CONSULTEE RESPONSE (Arun District Council - Arboriculturist)

Reference: BN/46/25/PL

Proposal: Application for construction of 10no. dwellings with new access from Wandleys Lane, landscaping and areas for ecology & amenity space. This application is a Departure from the Development Plan and is in CIL Zone 3 and is CIL Liable as new dwellings.

Location: Land South of Wandleys Lane, Eastergate, PO20 3SE

ECO 2 - TREE PROTECTION FOR LAND AT WANDLEYS LANE, EASTERGATE

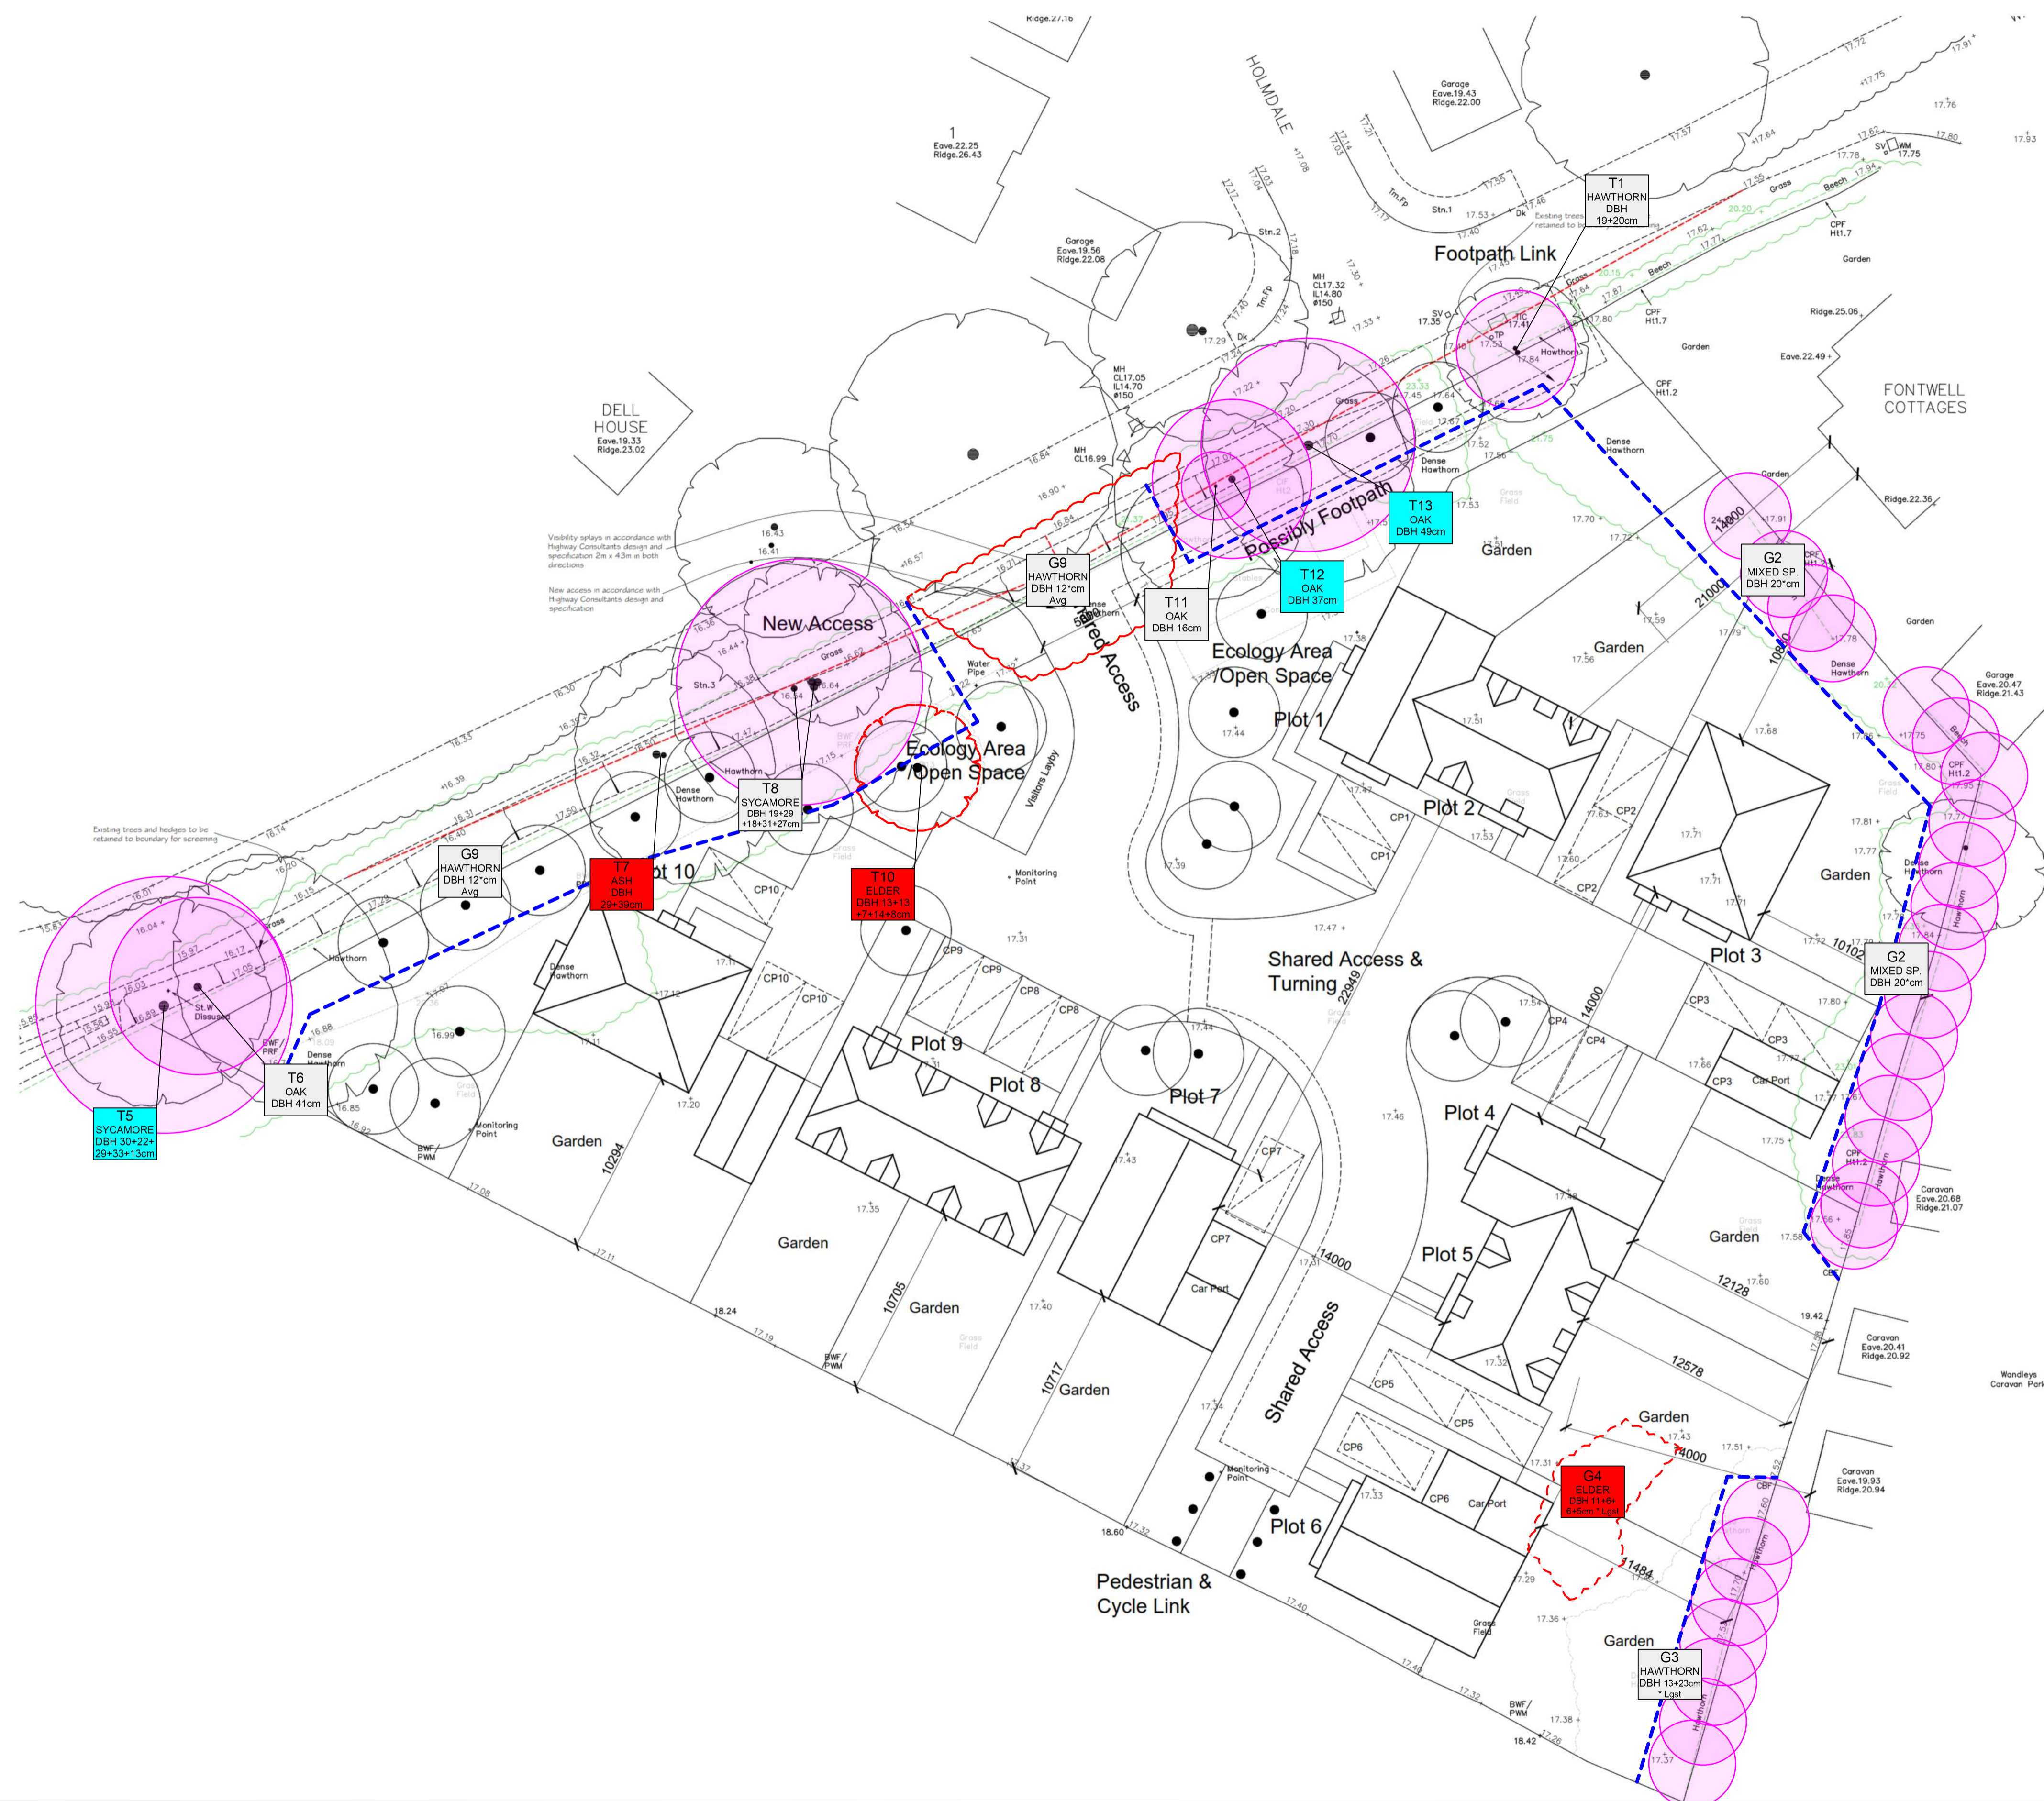
There is uncertainty around the footway proposal at the north of the site, which is likely to encroach into the root protection areas of higher value trees – T1, T12 & T13. It could be tolerable if works are undertaken sensitively and in accordance with the AMS guidance (see sect. 5.2).

Service-runs in and out of site have not been shown and so there is potential for tree/hedgerow removal and root protection area incursion, to satisfy those requirements. It is

assumed those will be routed due north to connect with existing infrastructure and avoiding the RPA of higher value trees but ideally we should have some knowledge of their location prior to a decision.

If there is deemed to be a need for any Utility Service Route connections to bisect retained tree Root Protection Areas/Zones, then prior to their installation a Method Statement prepared by an Arboricultural Expert must be submitted that stipulates how this can be achieved without adverse impact on tree roots. Written approval and confirmation of acceptance of this Methodology must be issued before any works are commenced out on site.

Drawing Status	PLANNING NOT FOR CONSTRUCTION
Client	Landquest UK (Southern)
Project	Wandley Lane, Eastergate,
Drawing Title	Proposed Drainage
Scale at A1	1:200
Date	Mar. '25
Drawn By	JHL
Checked By	MJA
Project No.	D2345
Drawing Code	000-BPC-WD-ZZ-D-C
Drawing No.	PL007
Rev.	-

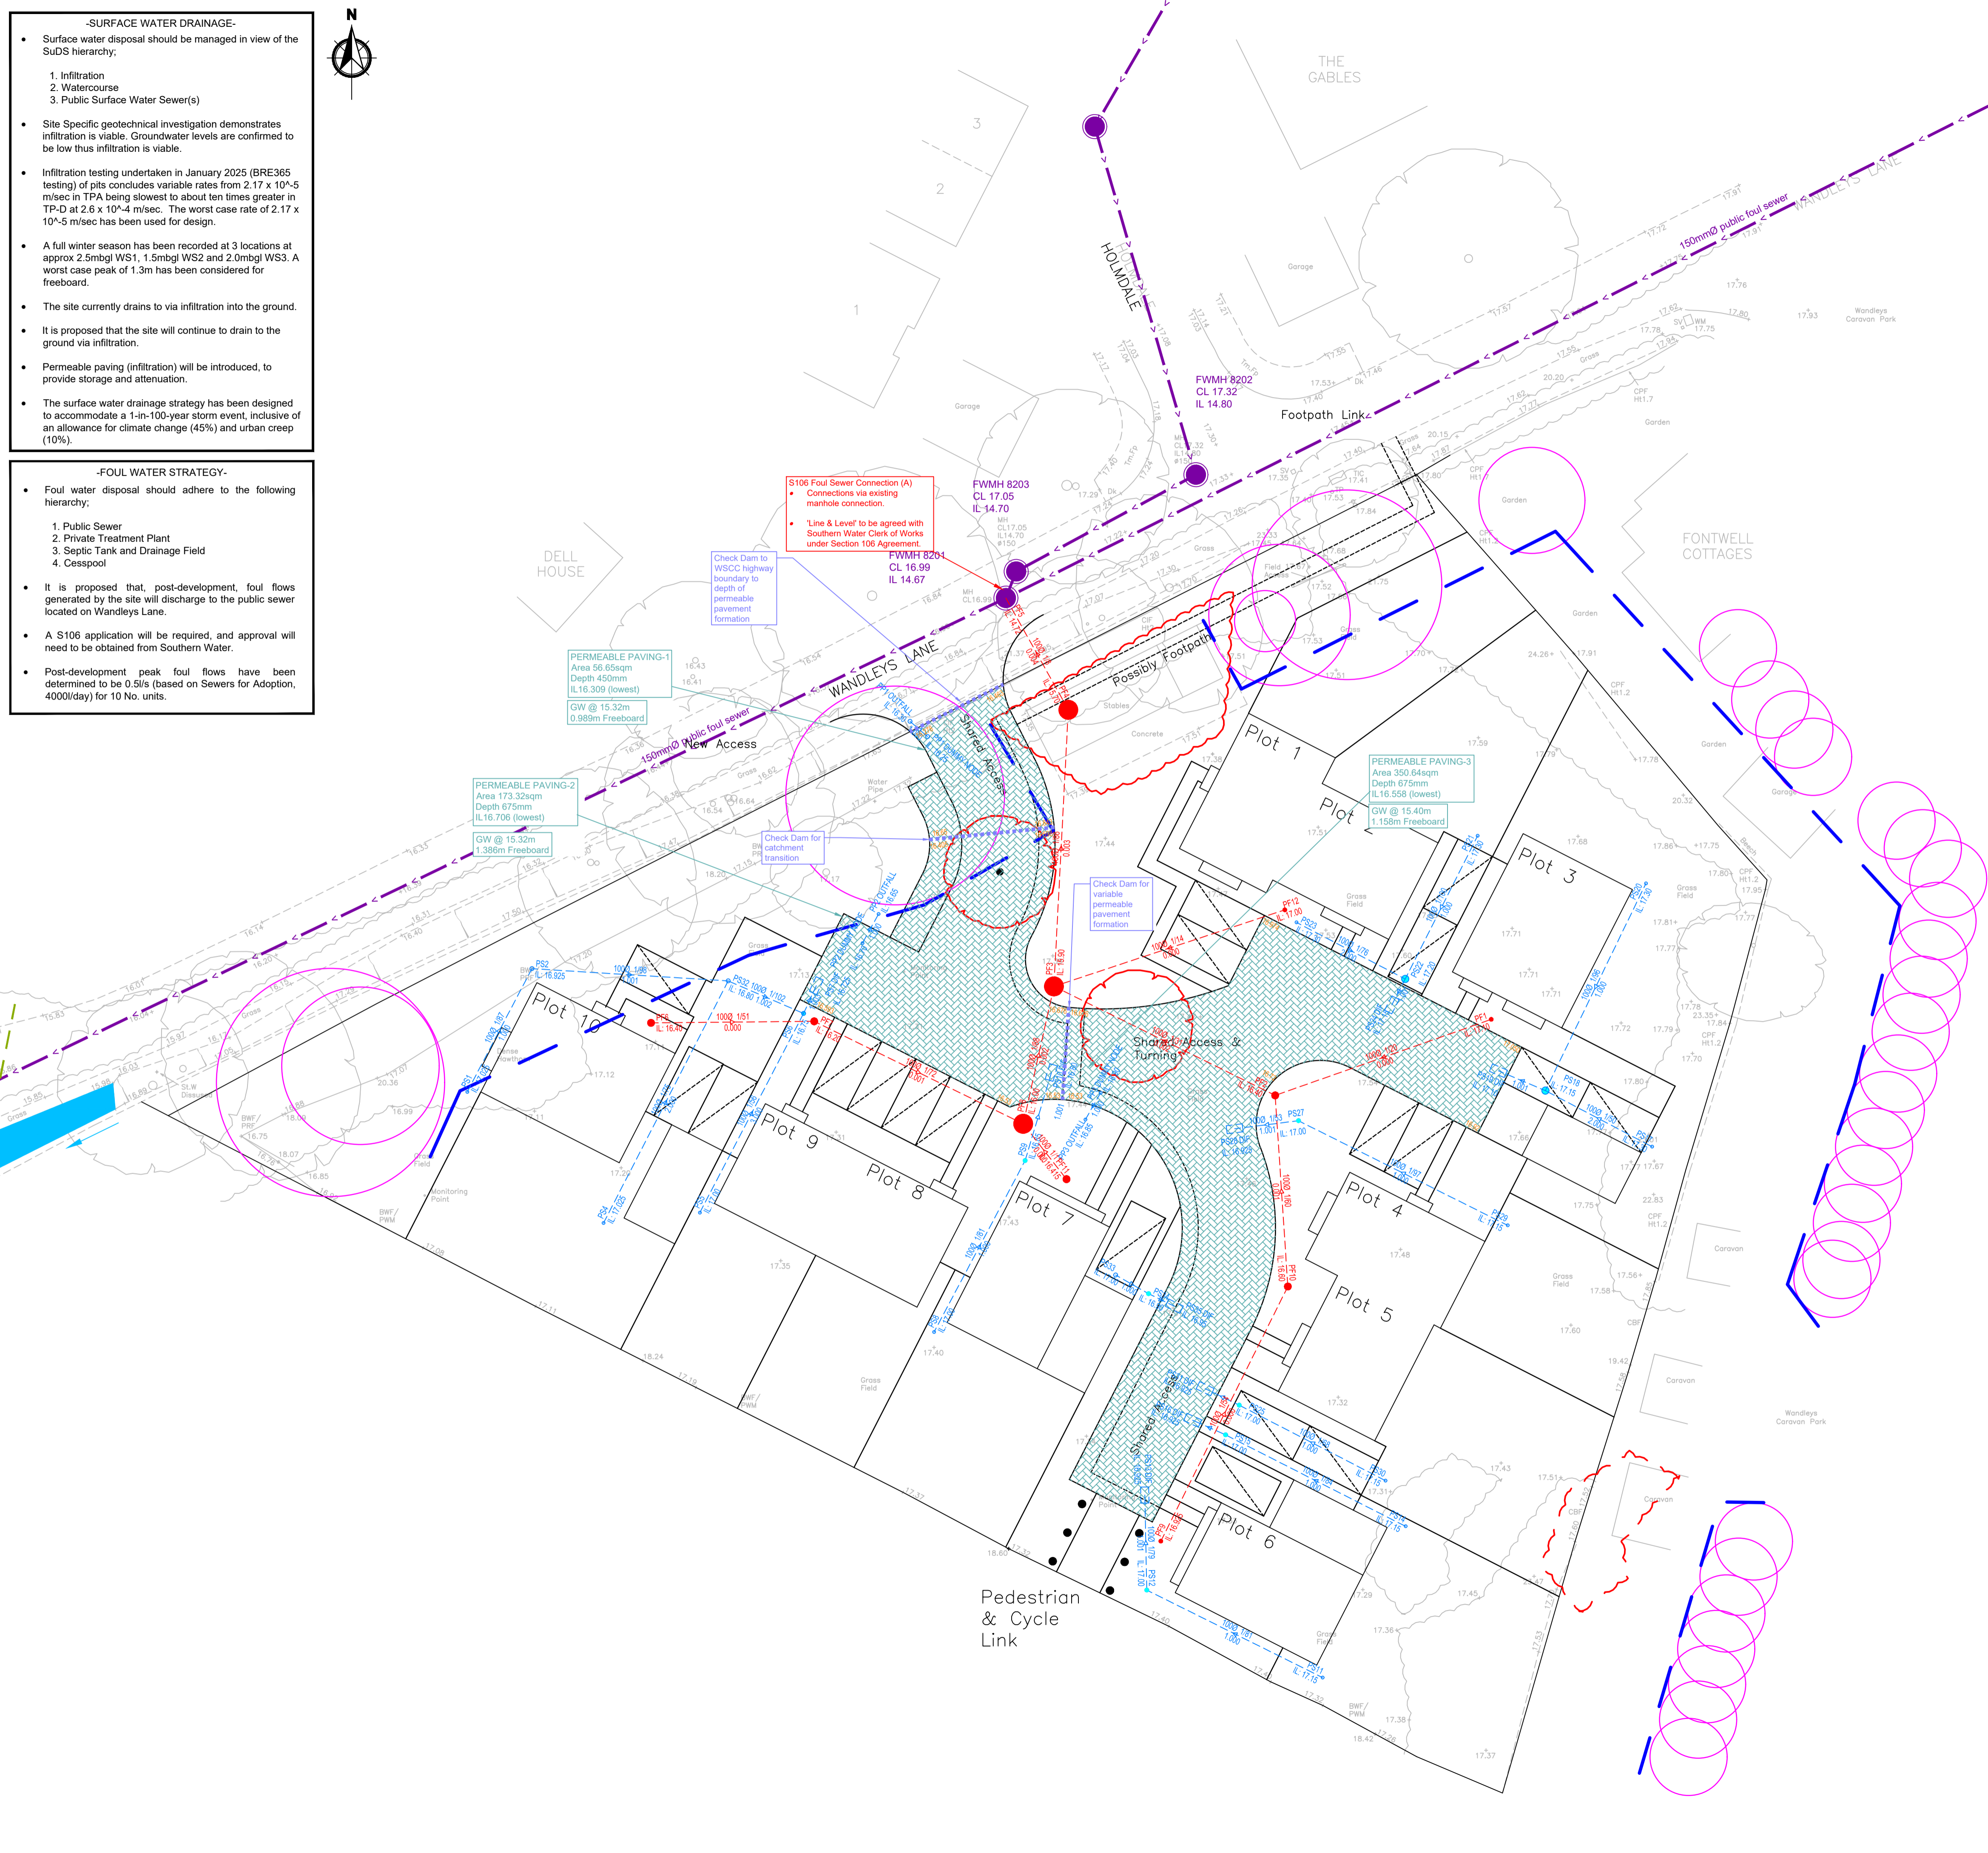
WSSC have approved the surface water drainage strategy in principle, and I see no obvious conflict with retained trees and hedgerow. They have approved the following plan - Drawing Proposed Drainage Plan Dwg. 000-BPC-WD-ZZ-D-C PL007 Rev 0. This plan should not be relied upon if used to consider the relationship between proposed drainage infrastructure and retained trees; the arboricultural consultant's tree survey data appears to have been overlain incorrectly.
